Town & Country Planning (Control of Advertisement) (England) Regulations 2007 (as amended)
Application for Consent to Display an Advertisement(s)

Development 1no.externally illuminated fascia sign & non-illuminated hanging signs

Location 52-56 Ferring Street Ferring

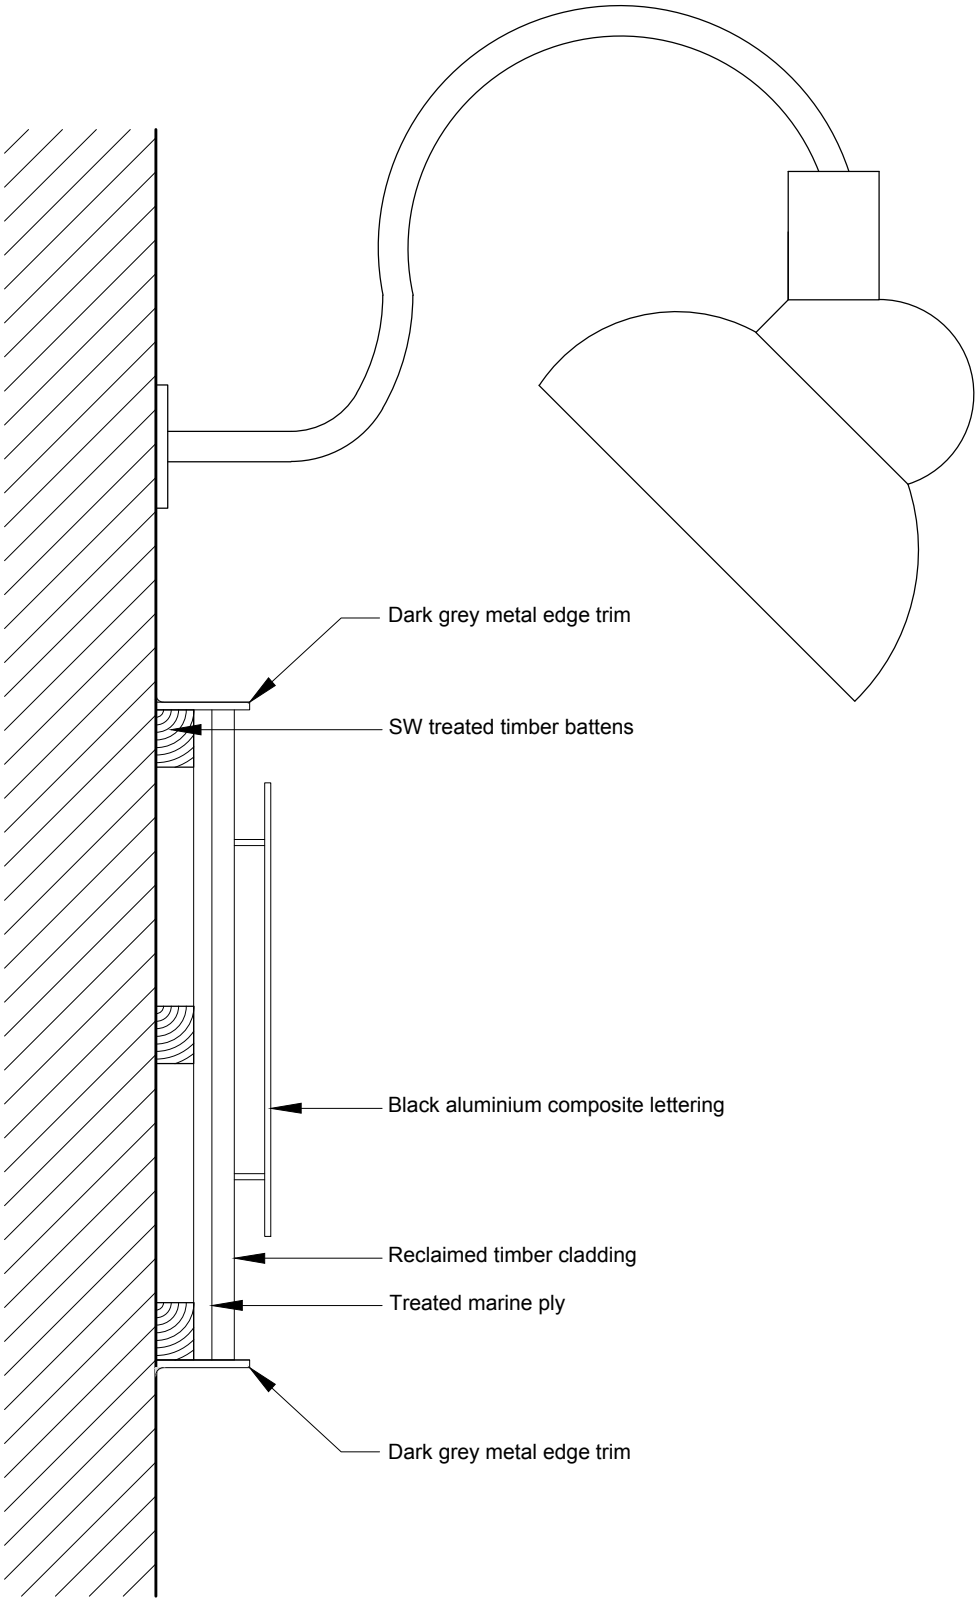
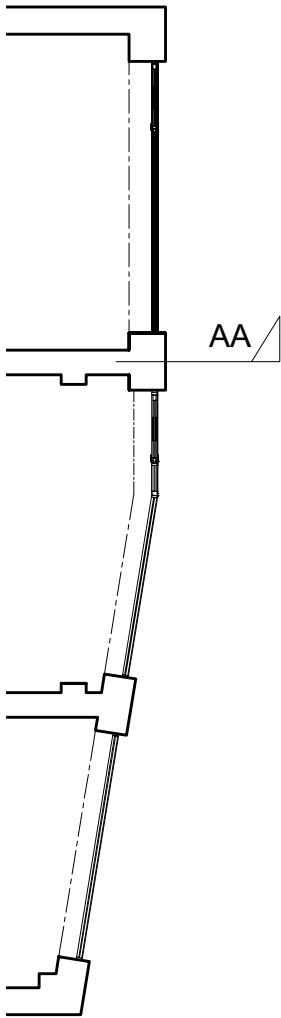
Please confirm how many hanging signs are proposed. Plans show two, however, the description states one.

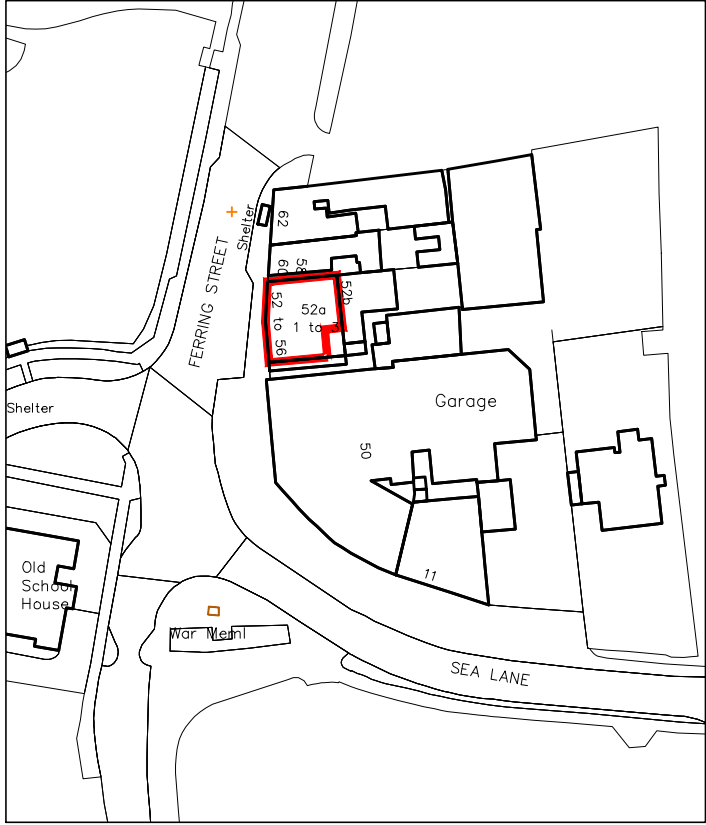
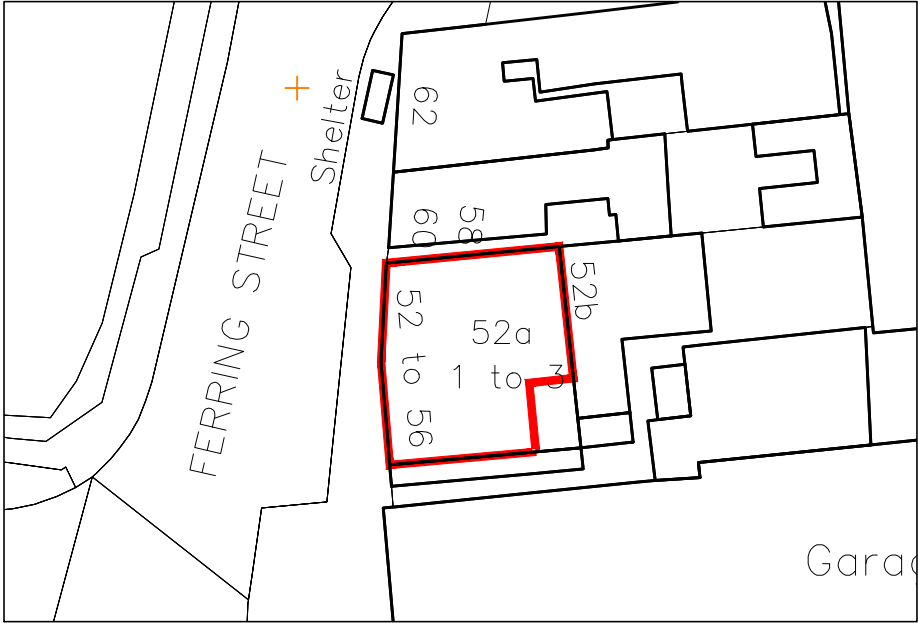
Block Plan

Please submit 1 electronic or 3 paper copies of an amended block/site plan at a scale of 1:500 or 1:200 showing the position of the proposed signage
